Application for a non-material amendment following a grant of planning permission.

ERECTION OF 2NO. DETACHED DWELLINGS, ADAPTION TO EXISTING CROSSOVER & NEW DRIVEWAY (RESUBMISSION FOLLOWING WA/58/18/PL).	
Reference number:	WA/18/19/PL
Date of decision	06/06/2019

+ enlargement of the front door canopy
+ external expression of the chimney
+ variation of the size and configurations of the windows
+ omission of cladding to the external elevations
+ variation of locations of brick and render to external elevations
+ brick plinth to be extended to whole of base of proposed dwellings

project + location
1 Orchard Way: Fontwell BN18 0SH
Quay Contracts+Jim and Cathy McMonagle
drawing number
nb:17101+101
drawing scale
1/100
@A1
drawing title
proposed new dwellings
drawing date
planning application-non material
amendment-01

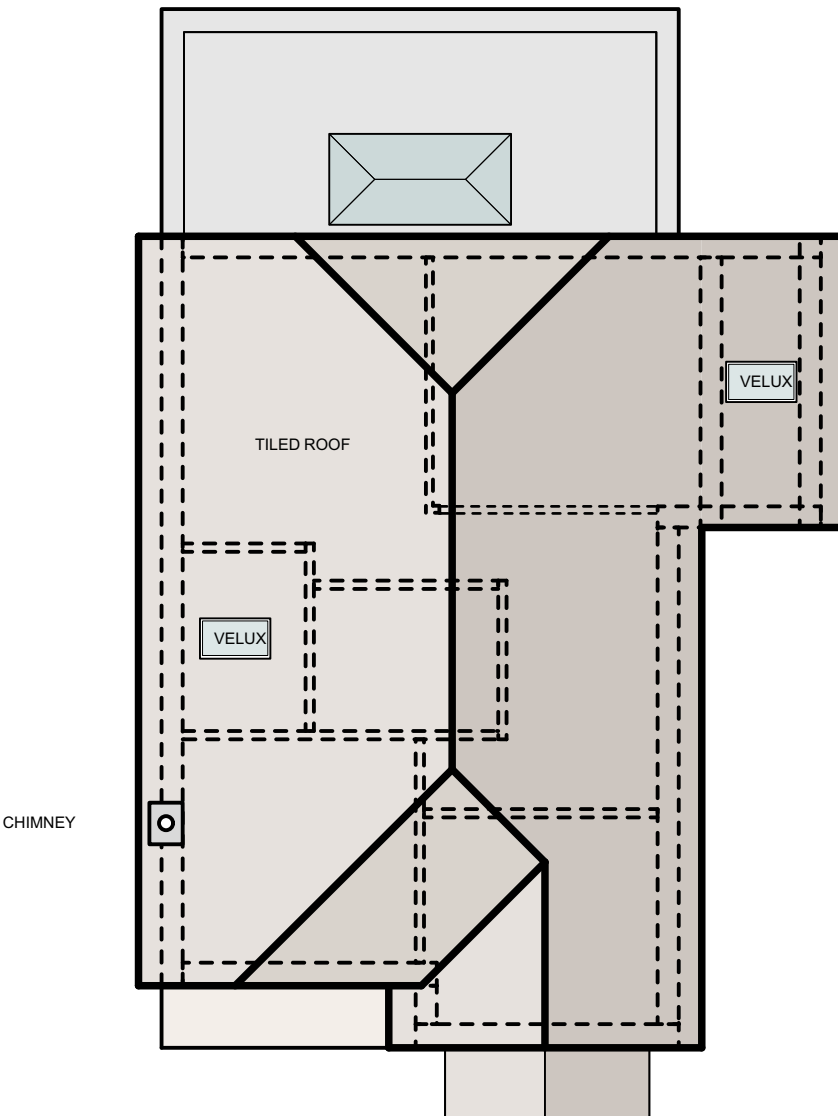
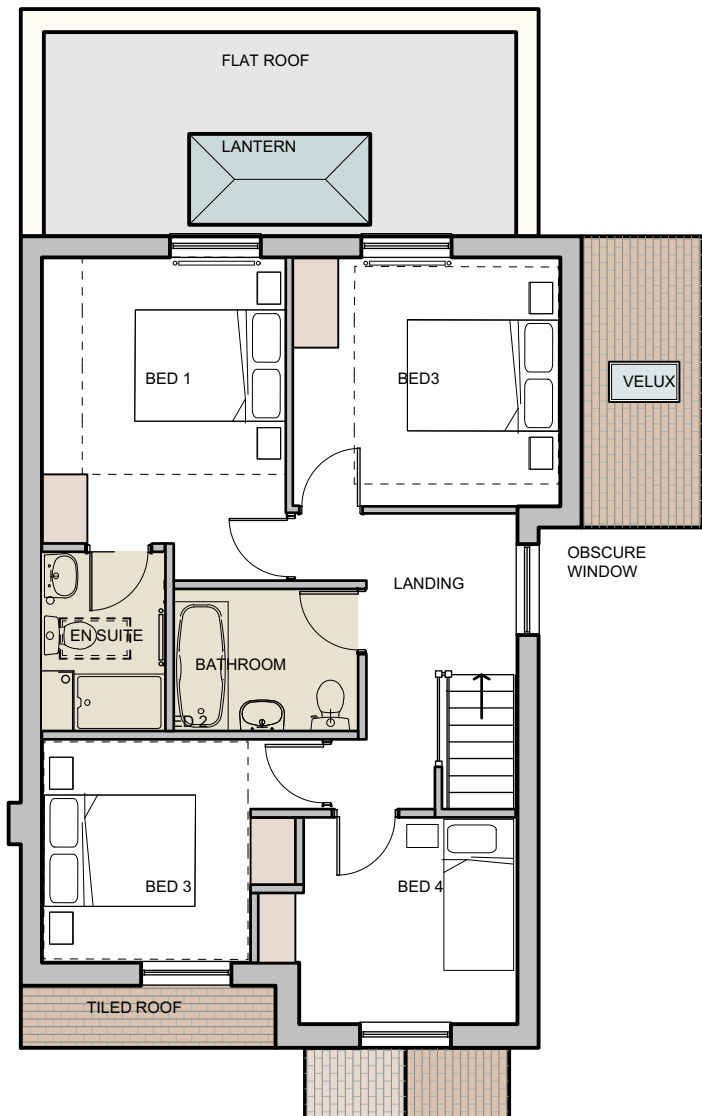
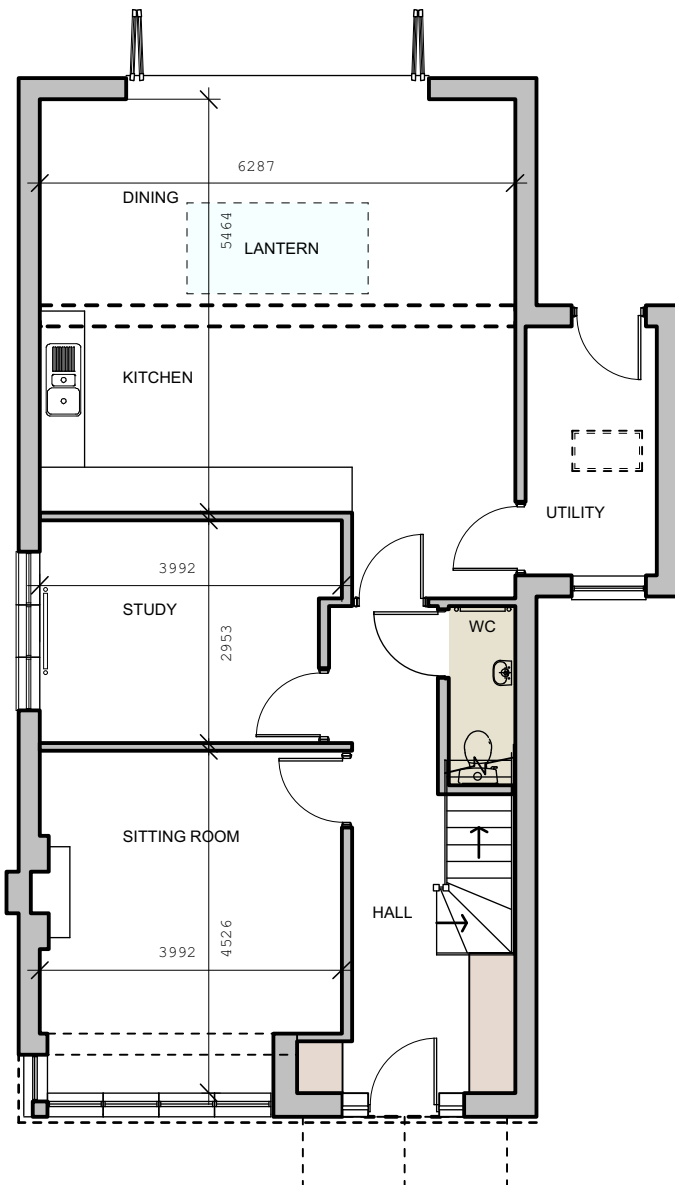
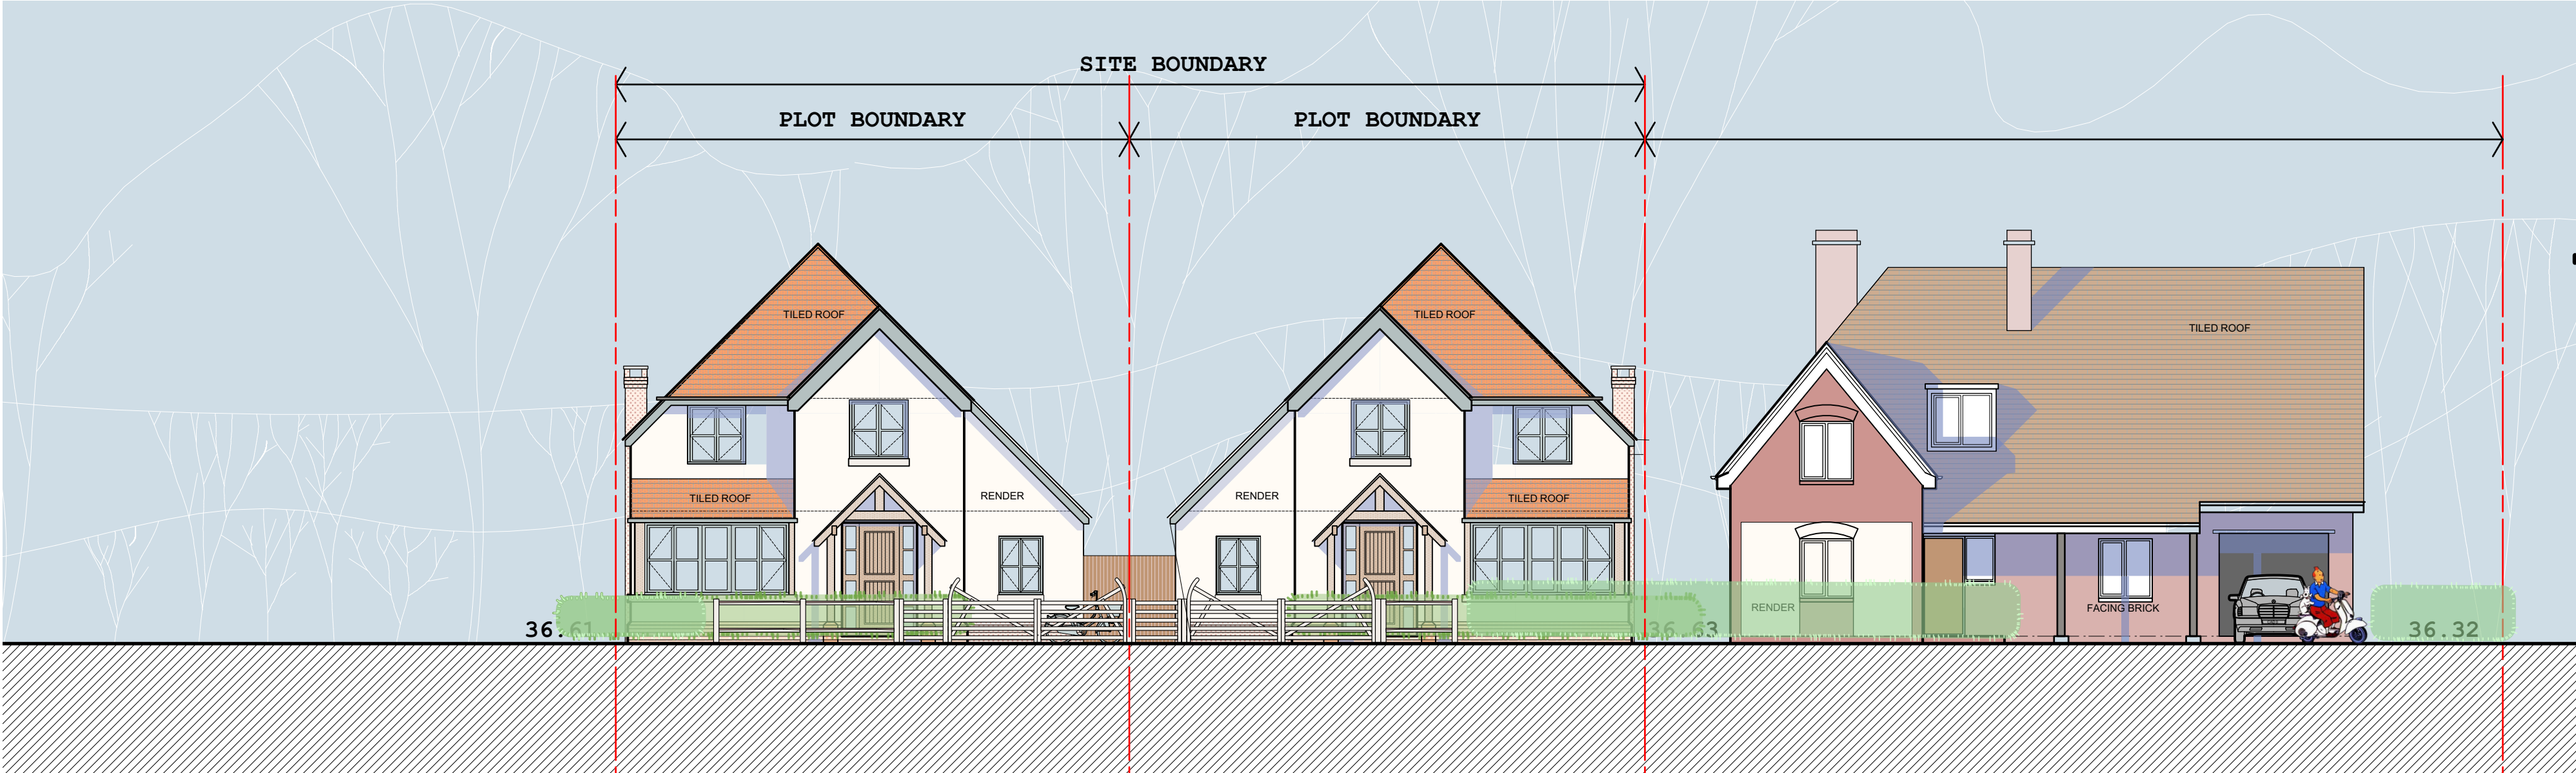
substitute:
+ nb017101/10k
new:
+ nb017101/11
+ nb017101/12
